Project Title: Land South of Grevatts Lane/ A259

Report Reference: JNY10830-09

APPLICATION REF: M/16/22/PL – WSCC PROW TEAM COMMENTS

APPENDIX A – RIGHTS OF WAY STRATEGY (171-UW-P-B-026) PLAN

B 1 Scale 1:50 - Cross-section
Section from intersecting road, facing north east

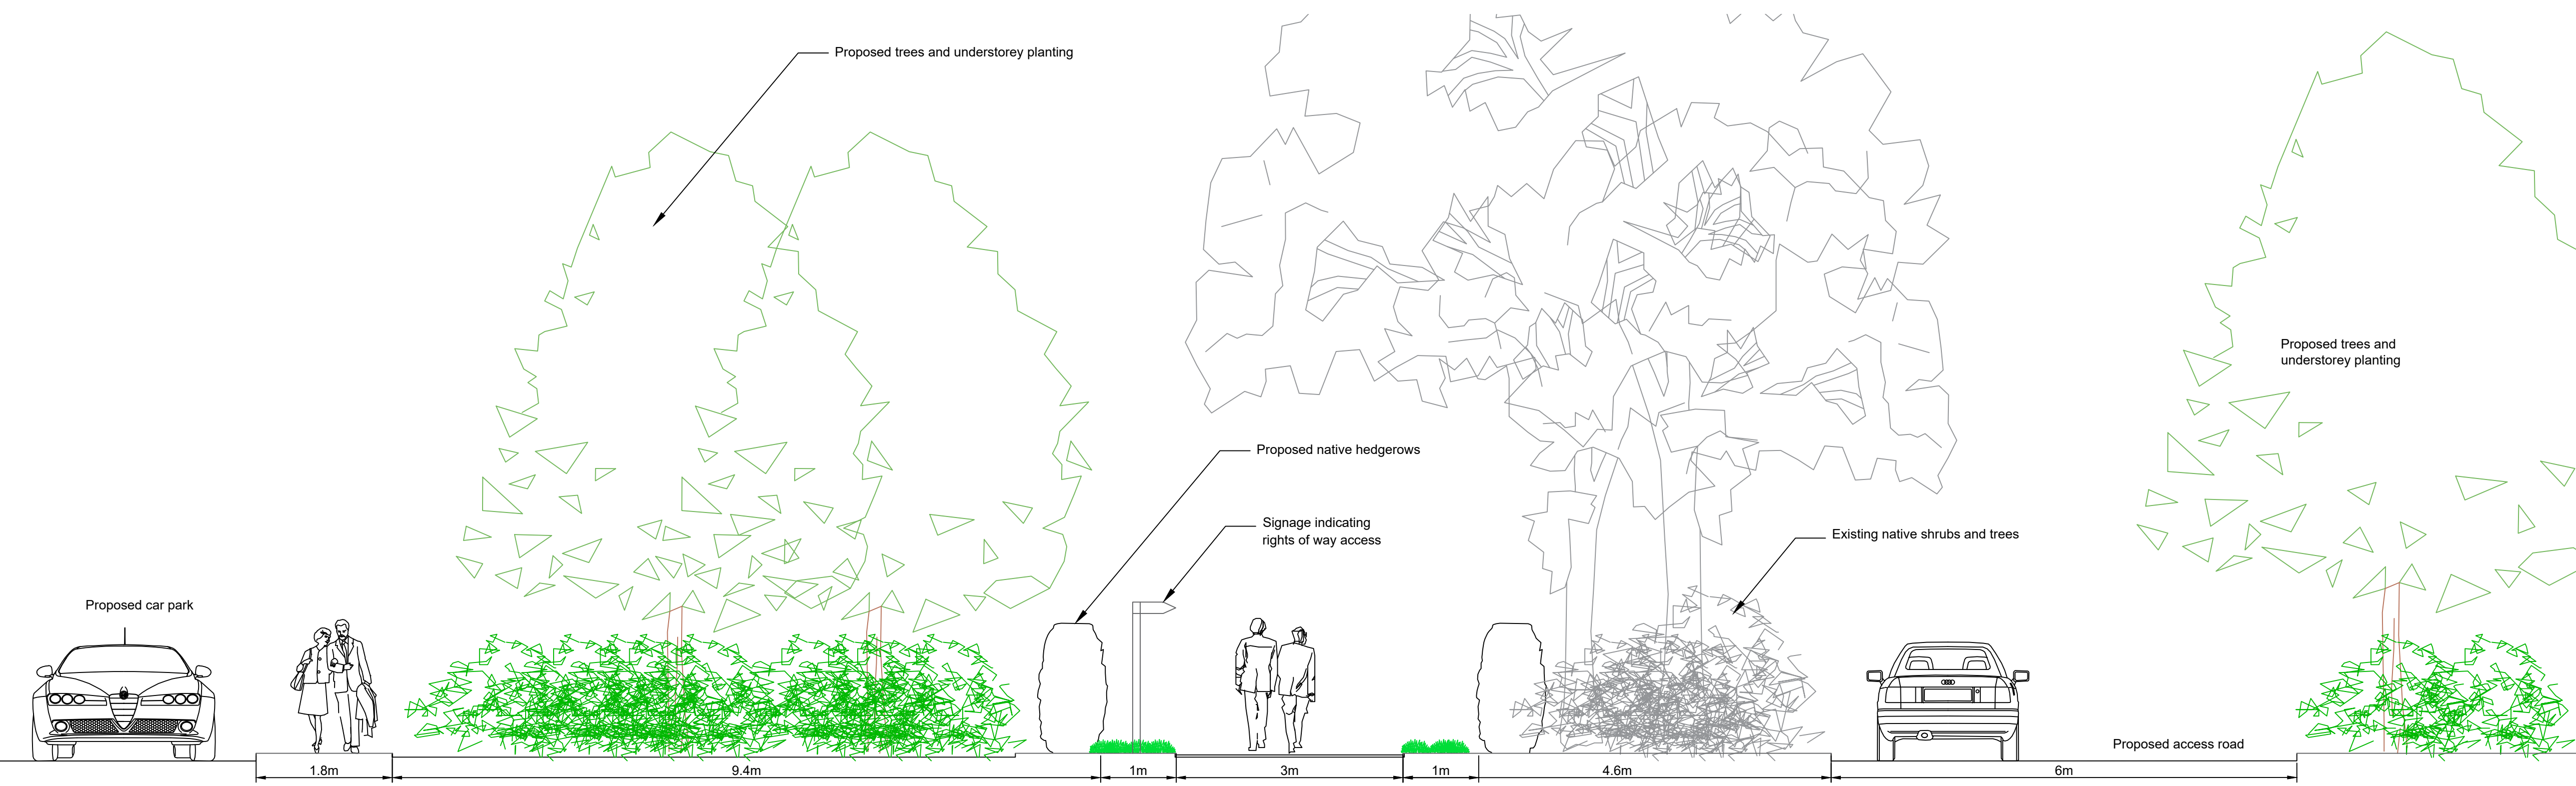
- 1.3 *The existing Public Right of Way (PRoW), Footpath 165 (FP165) is shown correctly on the plans and I see no plans to divert it.*
- 1.4 *There is some confusion over the status of the PRoW going forward. The PRoW's current legal status is as a Footpath. The developer's Rights of Way Strategy refers to it as an existing Bridleway.*

- 1.5 *Para 5.8 on page 82 of the Design and Access Statement (DAS) states the PRoW is to be improved to accommodate equestrian use. This would require a legal upgrade of the PRoW to Bridleway status and would also allow cyclists to continue along it, off road, from the site's vehicle access point, connecting all users from the A259 (and thus, South Coast Cycle Route 02) to the development to the south.*

- 1.6 *I could not see any other reference to upgrading any part of the PRoW to make it suitable for equestrian use however. In fact, para 5.23 of the Transport Plan states only the surface of the northern section will be improved and the figure on page 59 of the DAS supports this, showing the footpath will remain as a footpath in the southern portion of the site.*

- 1.8 *Any application to upgrade a footpath will take continuity into account. We would not support a partial upgrade that wouldn't allow cyclists and equestrians to continue along the route.*

- 1.10 *In this instance therefore, the PRow should, along its entire route, either;*
- *remain a footpath, pushing cyclists off the access connection into the road from the point the PRow starts and barring equestrians from using it at all, or*

- *be upgraded and made suitable for pedestrians and cyclists under a Permissive Path Agreement, or*
 - *be upgraded to Bridleway and made suitable for pedestrians, cyclists and equestrians.*

- Please clarify what your intention is.*
- 1.13 *Should either a bridleway or permissive cycle path be sought, please note we would require a minimum 3m width.*

- 1.7 References to the PRoW as a bridleway at Para 5.2 in the DAS and in the Rights of Way Strategy (171-UW-P-B-026) plan that supports the application have been made in error. The proposal is to improve the northern section of the existing PRoW that continues through the site to provide an improved footpath for use by pedestrians.. The Rights of Way Strategy plan has been updated (see Appendix A) and submitted to Arun District Council.

- 1.9 As advised above, the intention is to provide an improved section of footpath for use by pedestrians, ensuring the continuity of the PRow footpath for pedestrians is maintained.

- *a permissive path agreement which is time limited and can be withdrawn.*
- 1.12 The proposal seeks for the PRow to remain a footpath along its entire length with cyclists connecting to the road from the point the PRow starts. This can be achieved safely and has been confirmed to WSCC Highways in response to their consultation comments. The proposals do not seek a change in the status of the PRow at this stage.

- 1.14 As advised above the proposal is to maintain the existing PRow footpath status. As set out at the Rights of Way Strategy (171-UW-P-B-026) plan the section of the route between the Ryebank Rife and the entrance to the site will be improved with a 3m wide footpath with planting either side. The remainder of the route south of the Ryebank Rife will be improved to make the route clearer, removing shrubs, etc. and the surface will be improved to provide a chipped bark surface or similar appropriate material taking account of existing TPO status of trees in this location. Proposed details to be secured by condition.

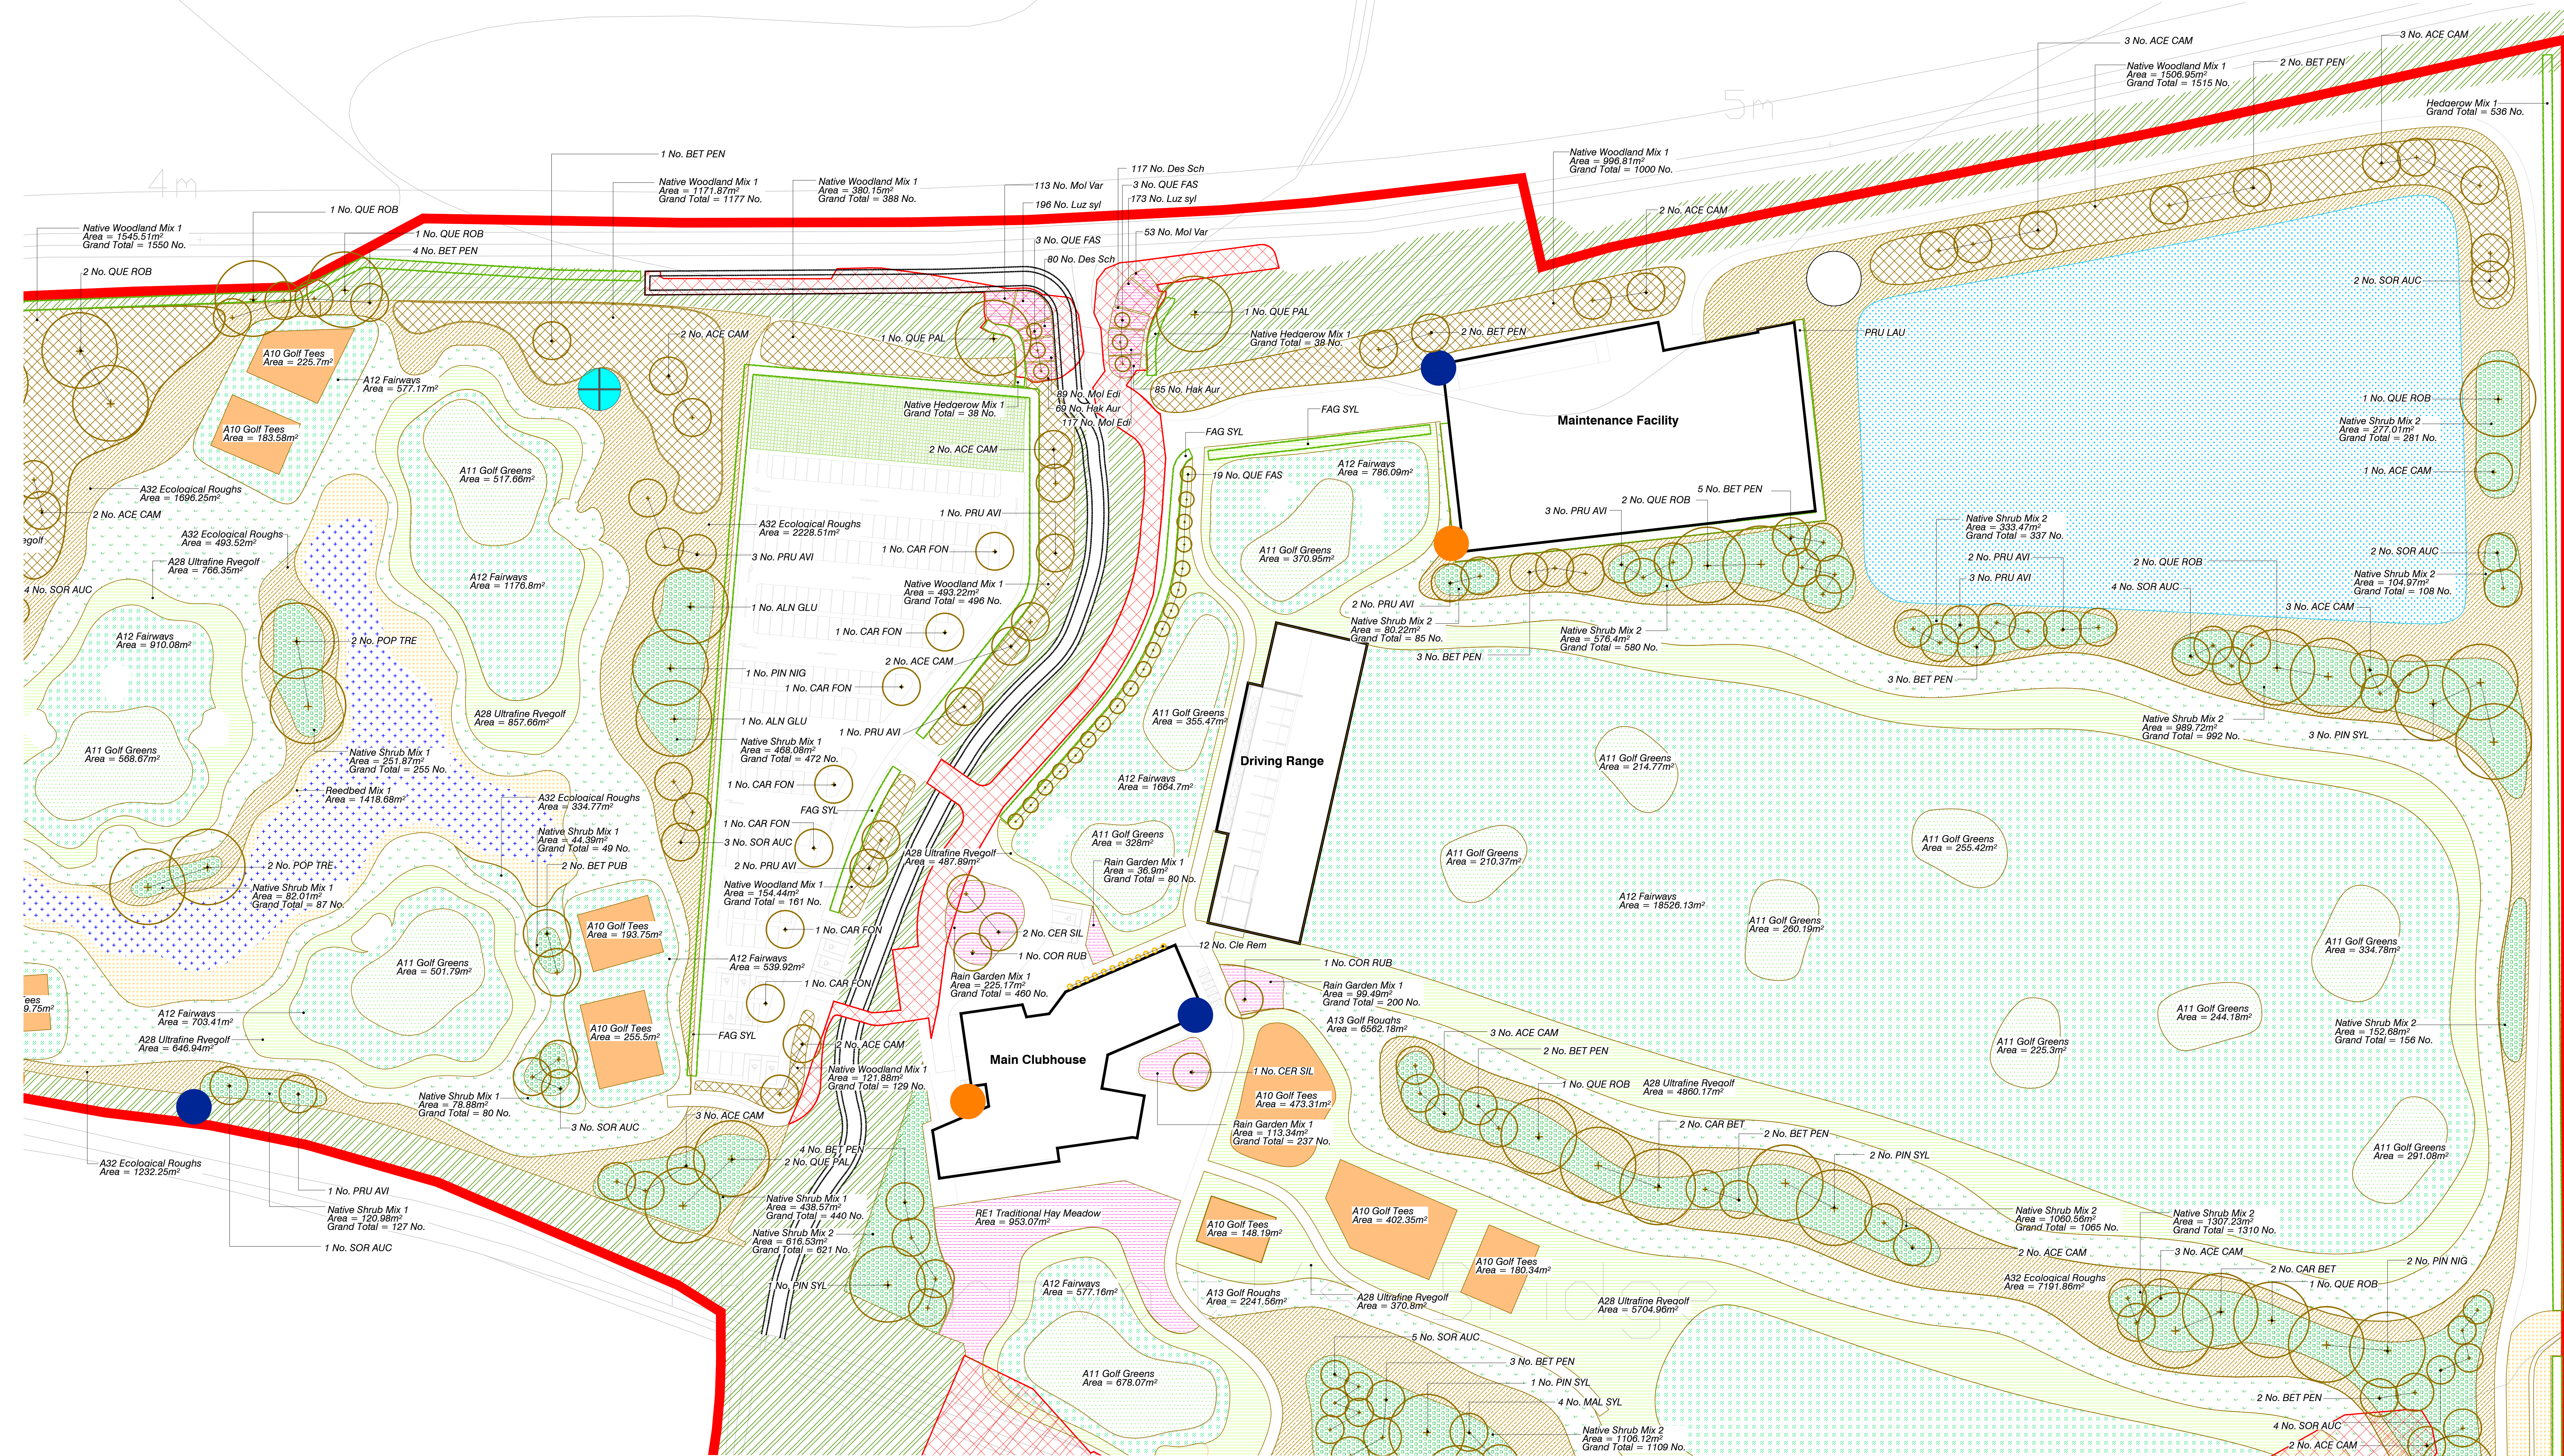
- 1.15 *With regards to the vehicle crossing points, the applicant is encouraged to introduce signage to advise vehicle drivers of the hazard and to act responsibly.*

- 1.16 Noted. The design has been based on providing suitable levels of intervisibility for pedestrians and vehicles at the crossing point which will be kept free of vegetation. Advance warning signage for pedestrians and vehicles will also be provided and agreed with WSCC via condition.
